July 22, 2014

RE: 102 Portland Street

Matt Provencal, Assoc. AIA
Architectural Designer
Mark Mueller Architects

Drawing file: 1. Original Plans / A2.003.Diagrammatical Section (View from Portland St).pdf

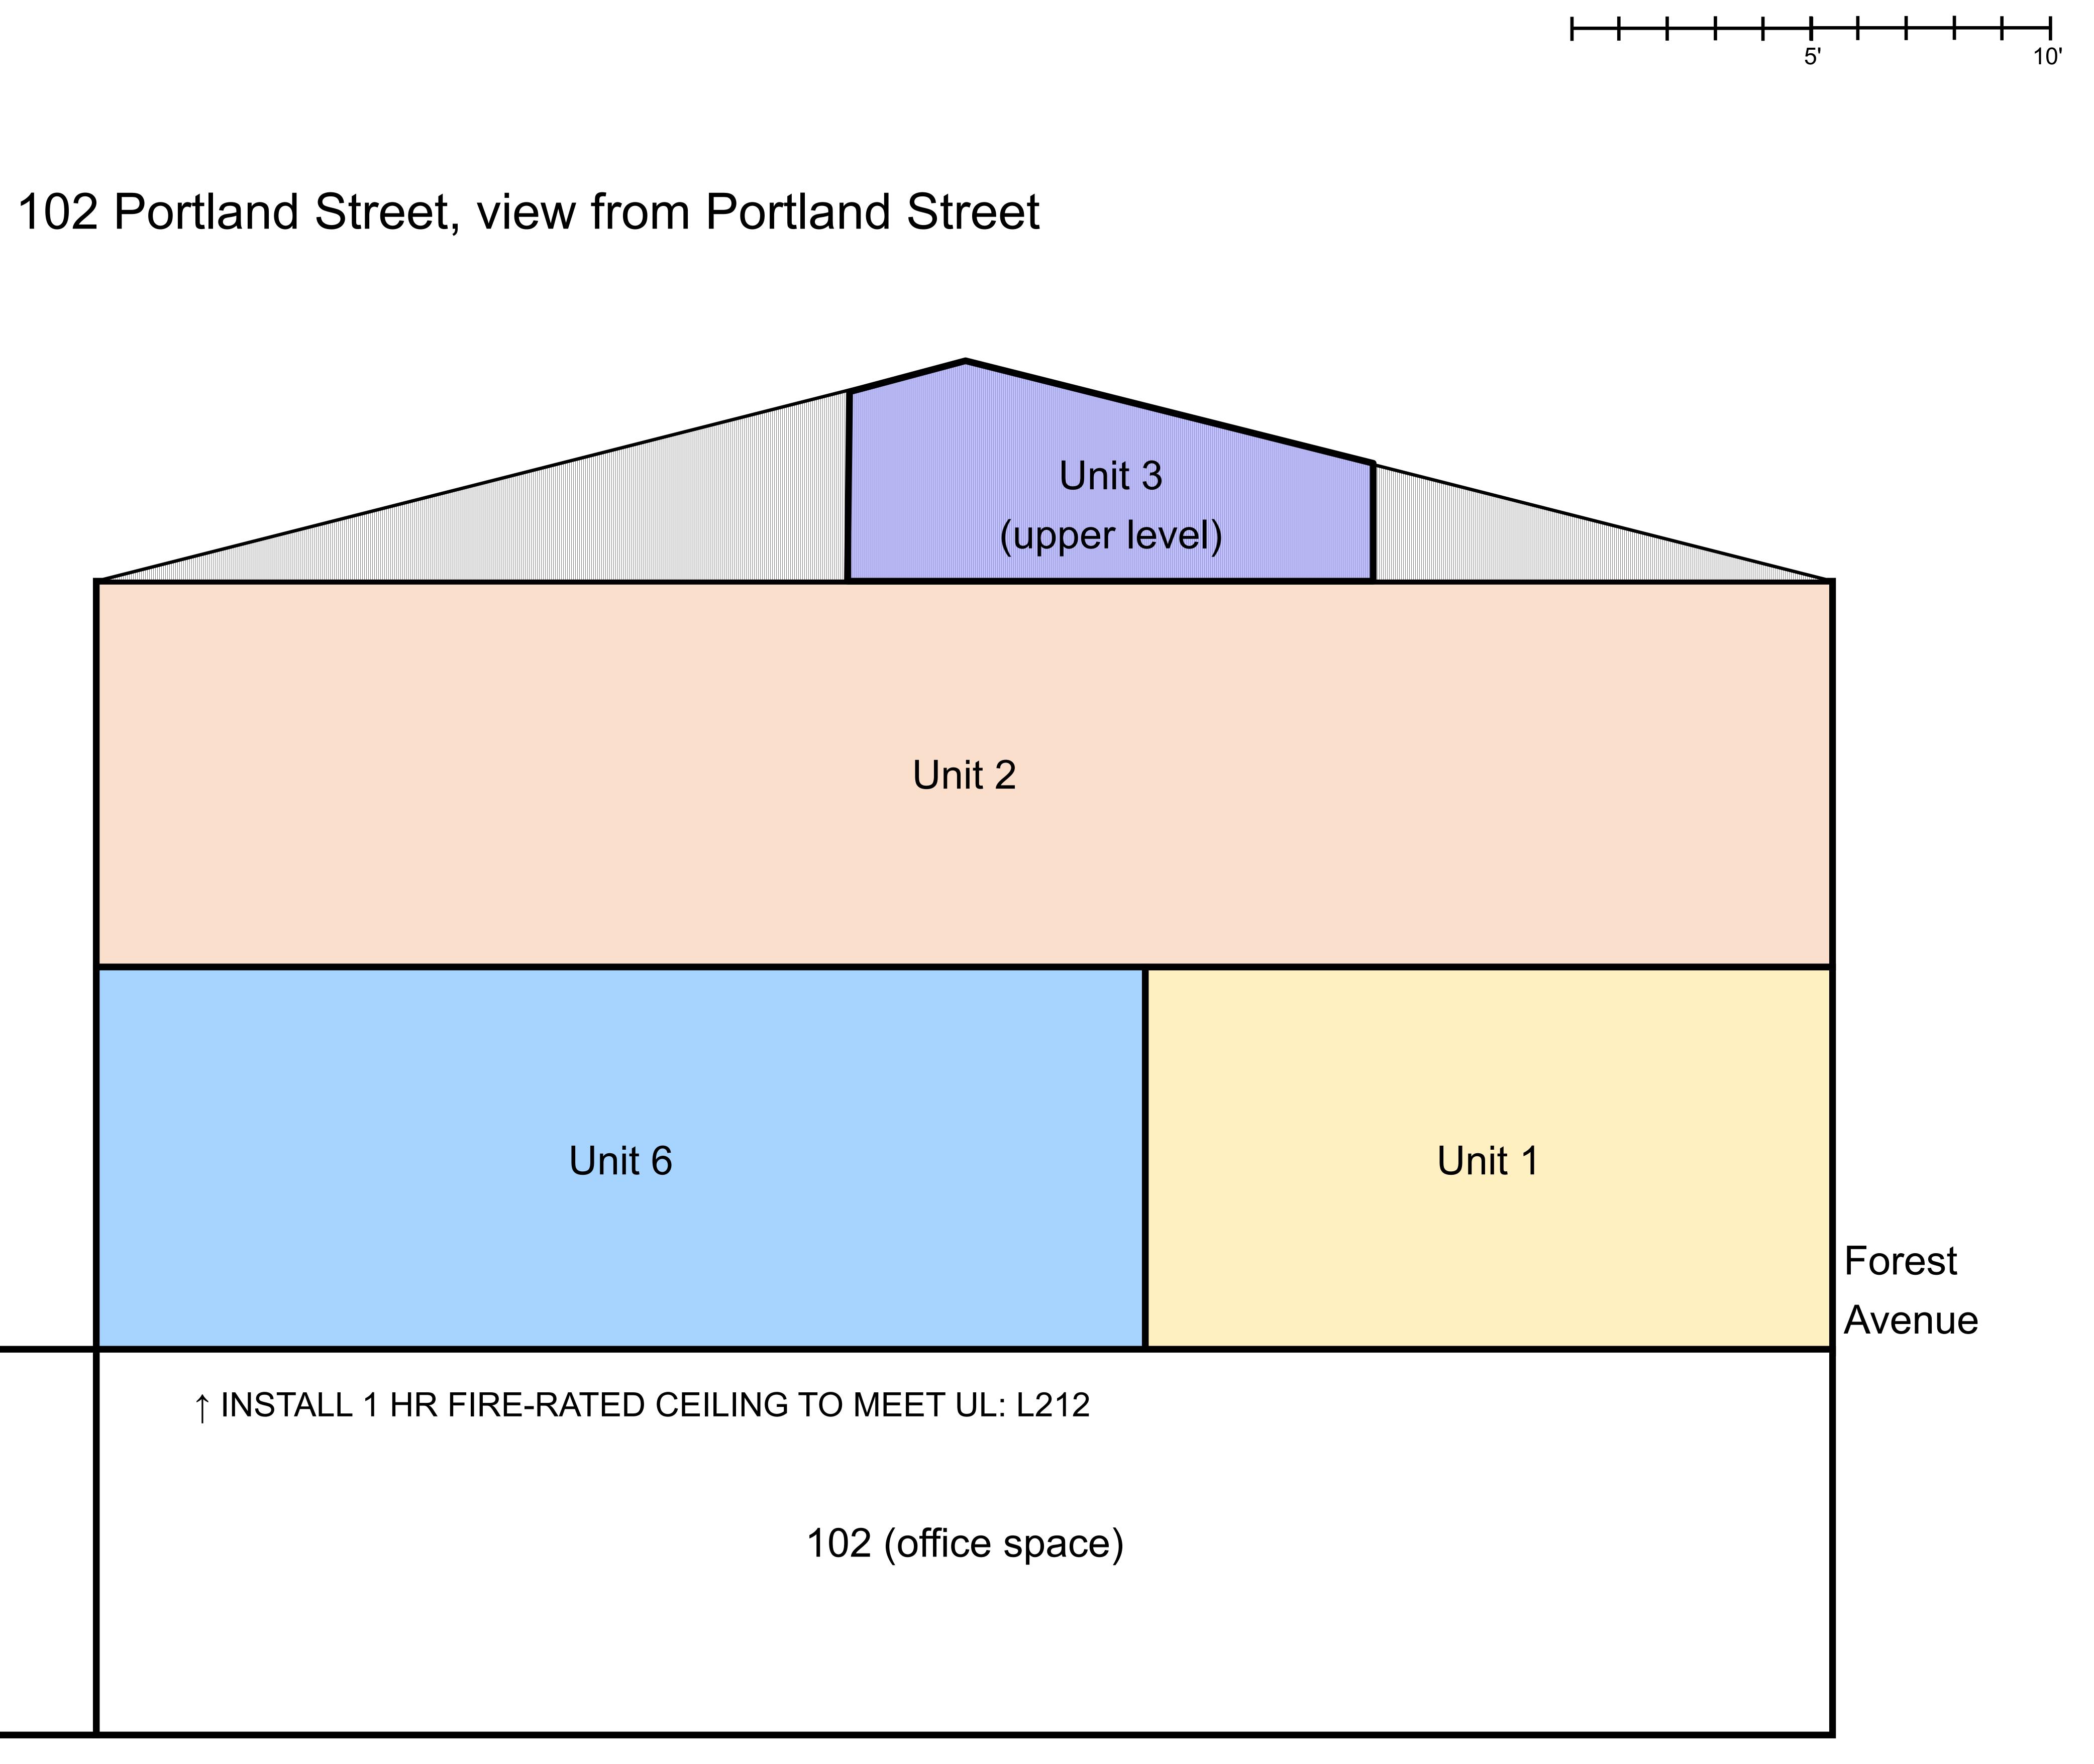
1. The 1st floor Mercantile or Business use must be separated from the residential uses by a floor/ ceiling assembly with a one hour fire rating. The space contains a suspended acoustical tile ceiling with no fire rating currently. We propose a fire rated floor/ ceiling assembly by a suspended GWB ceiling meeting UL L212.
